Recommendation Report for Planning Permission for Works or Extension to a Dwelling

REF NO: FP/114/21/HH

LOCATION: 14 Sutton Close
Felpham
PO218EY

PROPOSAL: Removal of existing structure & erection of single storey front extension.

sheet 1 a of 2

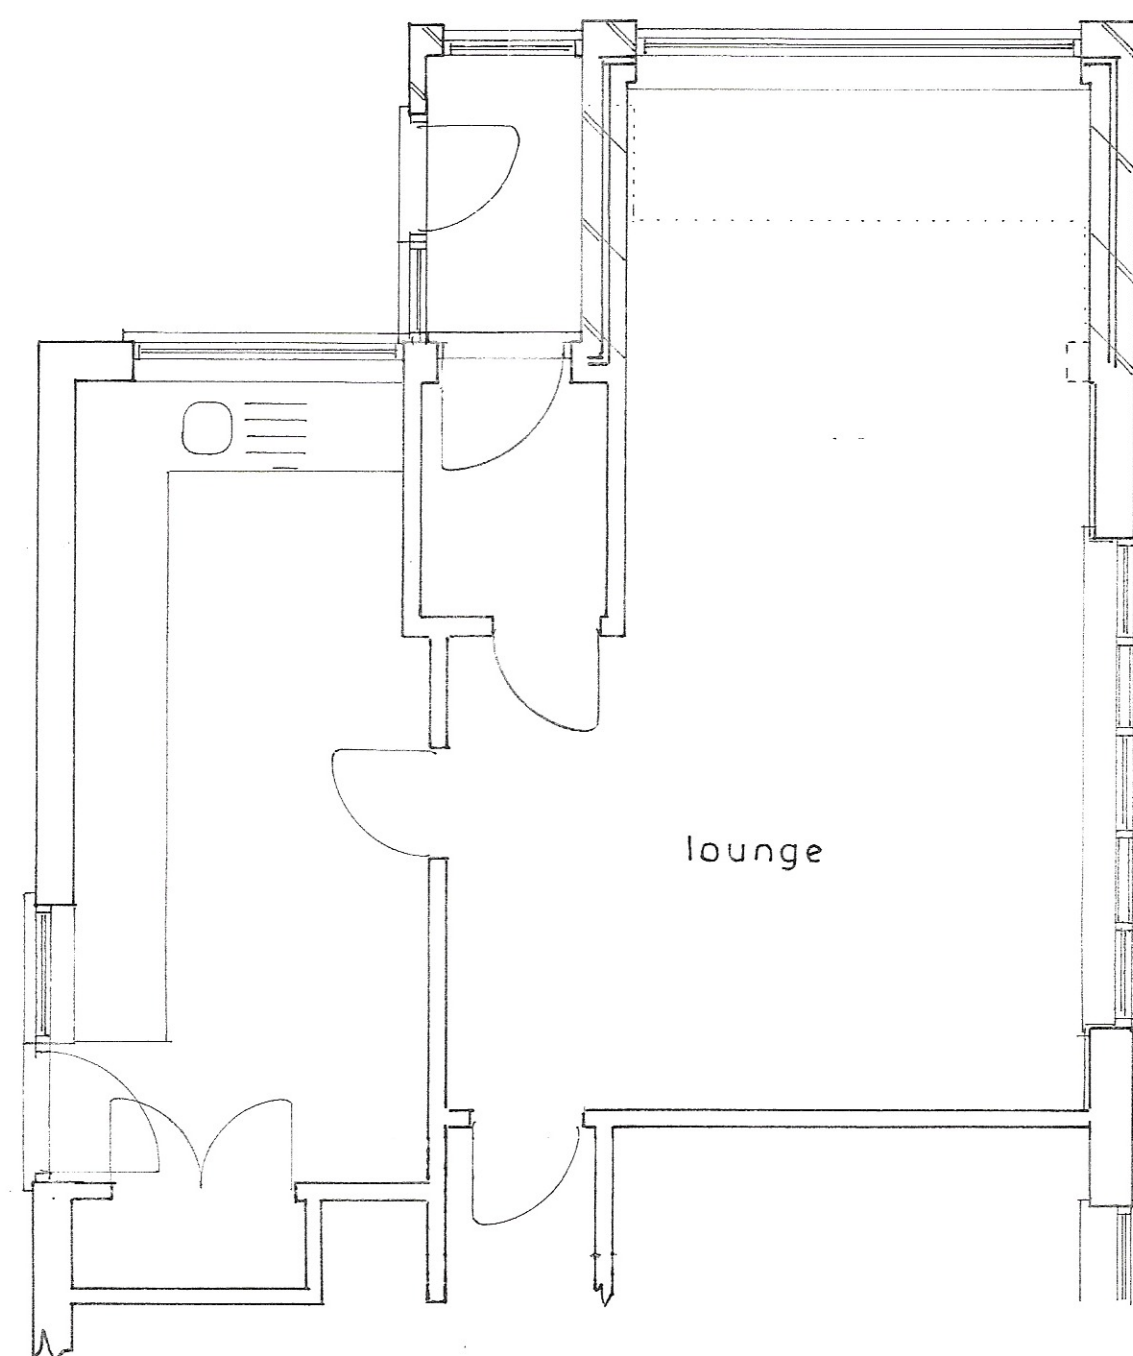
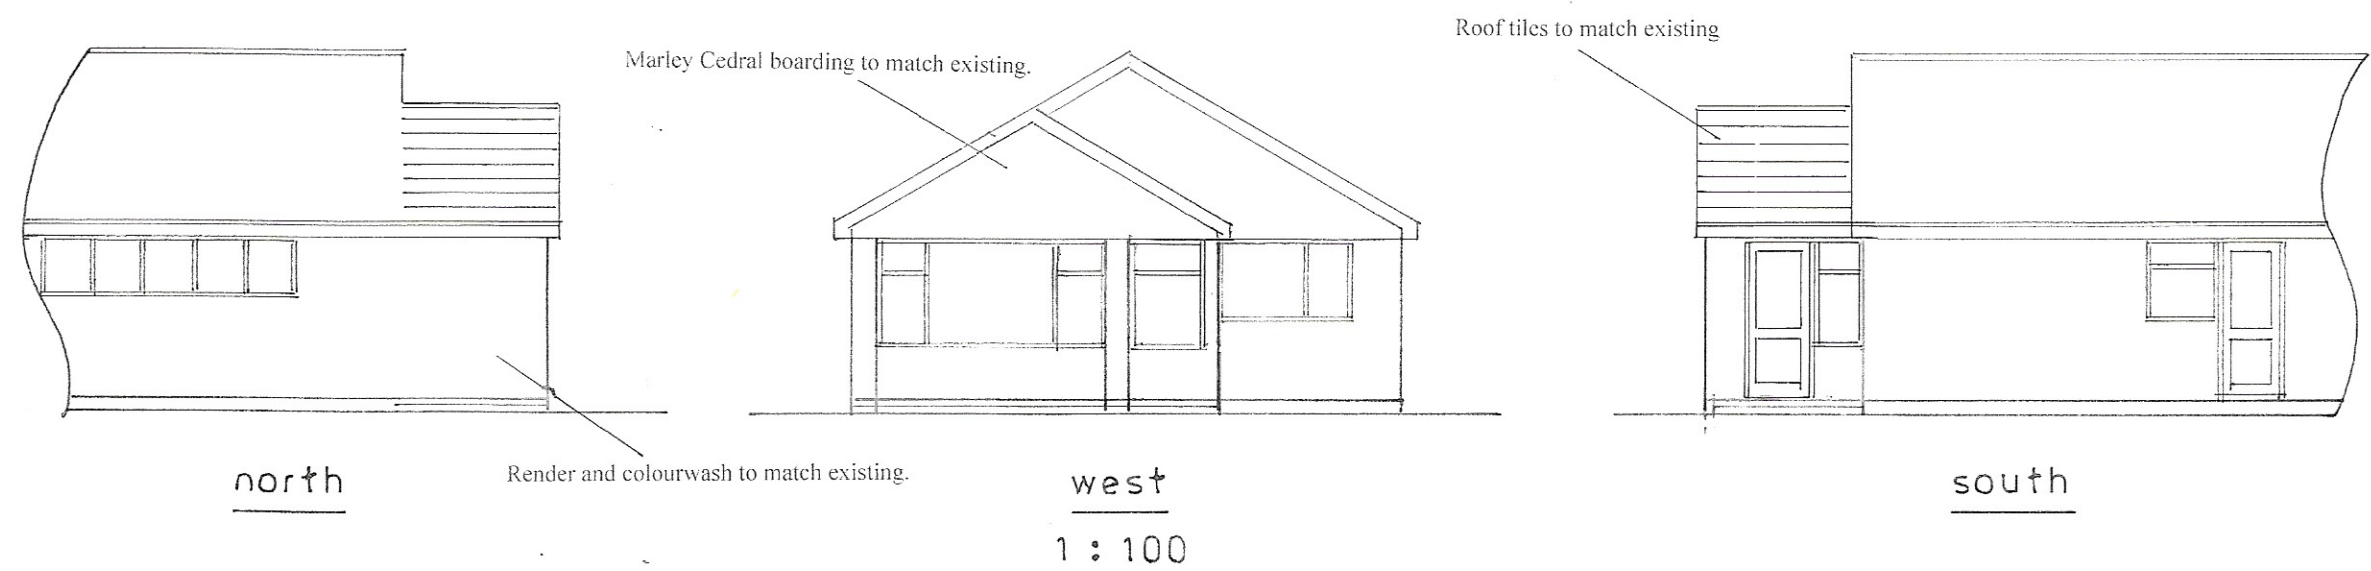
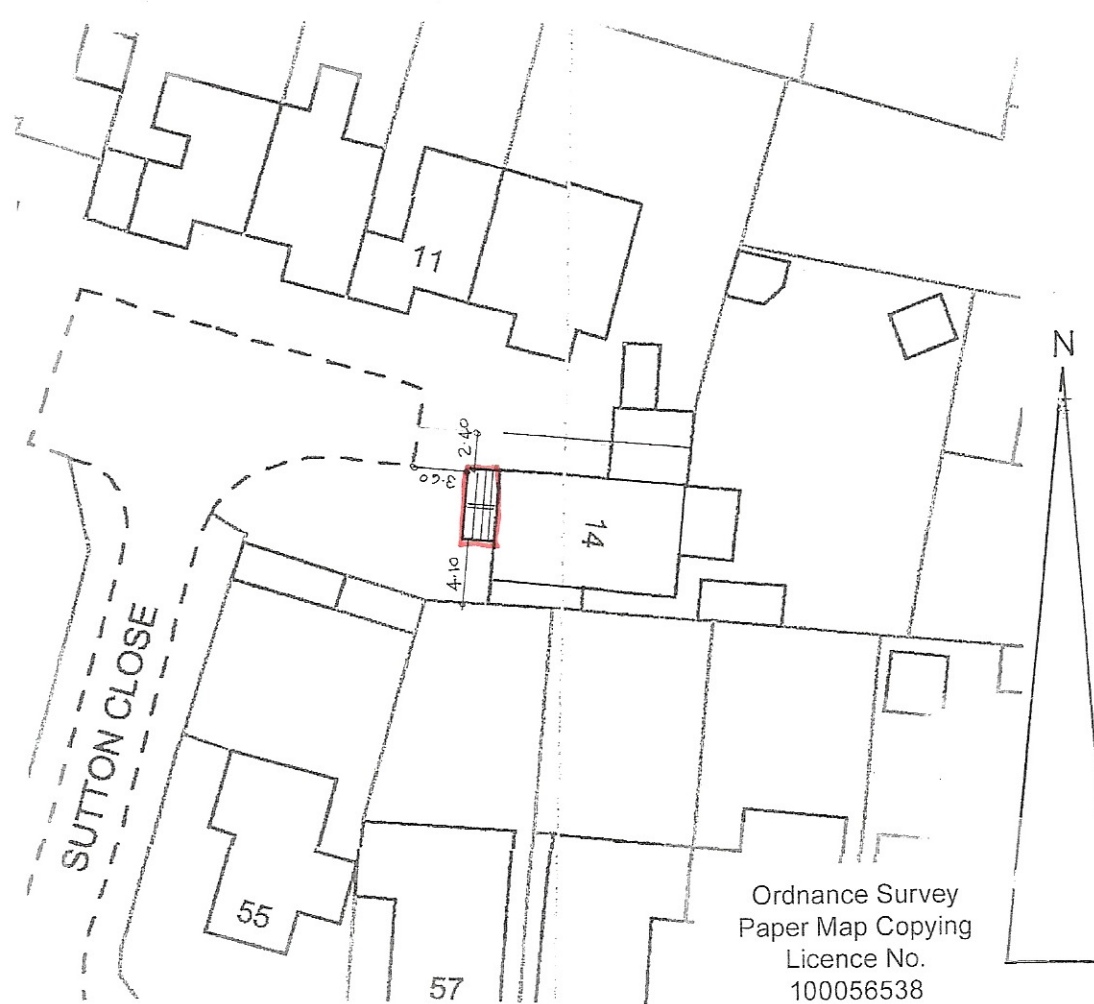
Due to the siting at front (west) of dwelling the proposals will be highly visible from street scene however the pitched roof design visually integrates with the dwelling being at single storey and the height beneath the main dwelling eaves height creates visual subservience so will not adversely impact street scene or surrounding character of area so will comply with policy D DM1 of the Arun Local Plan and policy ESD1 of the Felpham Neighbourhood Development Plan.

Due to loss of driveway space to front (west) it will reduce on site parking availability. However due to the driveway area remaining to front (north) it seems 2 spaces will remain available so this complies with Policy T SP1 of the Arun Local Plan and Arun Parking Standards.

The proposal will have a width of approximately 4.82m and a depth of approximately 2.34m. The height to pitched roof will be approximately 4.08m. There is a gap of around 4.0m remaining to the south boundary. The proposal will have 3 new windows in the front (west) elevation and another single window in the porch area of front (west) elevation. There will be a new front door and single window to the south elevation of extension.

Arun recently adopted a Design Guide. It states development should be subservient to the dwelling and this complies in terms of size and scale. It states front extensions must consider their impact on the surrounding street scene, and are more likely to be acceptable on streets with a staggered or set-back building line. It states that extensions should not project forward beyond the predominant building line. Whilst the extension is beyond the front building line, it is at single storey and pitched roof design is in-keeping so is acceptable. It also states front extensions should generally be no deeper than 1.5m and

should not be the full width of the building. Whilst the proposal is greater than 1.5m in depth (2.34m) it is not excessively so and is considered acceptable.

The materials seem to match existing property and consist of render and colourwash walls, Marley Cedral cement board cladding, roof tiles, UPVC windows and UPVC door so will comply with policy D DM1 and D DM4 of the Arun Local Plan, ESD1 of the Neighbourhood Plan the Design Guide.

The proposal will have a width of approximately 4.82m and a depth of approximately 2.34m. The height to pitched roof will be approximately 4.08m. Due to the siting at the front elevation there is increased risk to overshadowing or overbearing effect to 12 Sutton Close to north however due to 2.40m gap to northern boundary and building line to north set back there is no adverse harm to overshadowing or overbearing effects to north. There is slight increased risk to overshadowing or overbearing effect to 57 Wroxham Way to the south however due to the property to the south being set back from the southern boundary and being at single storey it does not give rise to adverse harm to overshadowing or overbearing effect to neighbouring property to south so is acceptable.

Due to 3 new windows in the front elevation of the extension and 1 single window in front (west) elevation of porch of extension there is increased overlooking to neighbouring properties to west. However due to Sutton Close road and large gap to nearest property to west there is no adverse harm to overlooking to neighbouring properties to west.

Due to a new door and single window in south elevation of extension there is increased risk to overlooking to neighbouring properties to south however due being at single storey and a gap of around 4.0m remaining to south boundary there is reduced impact to overlooking effects to neighbouring property to south so is acceptable.
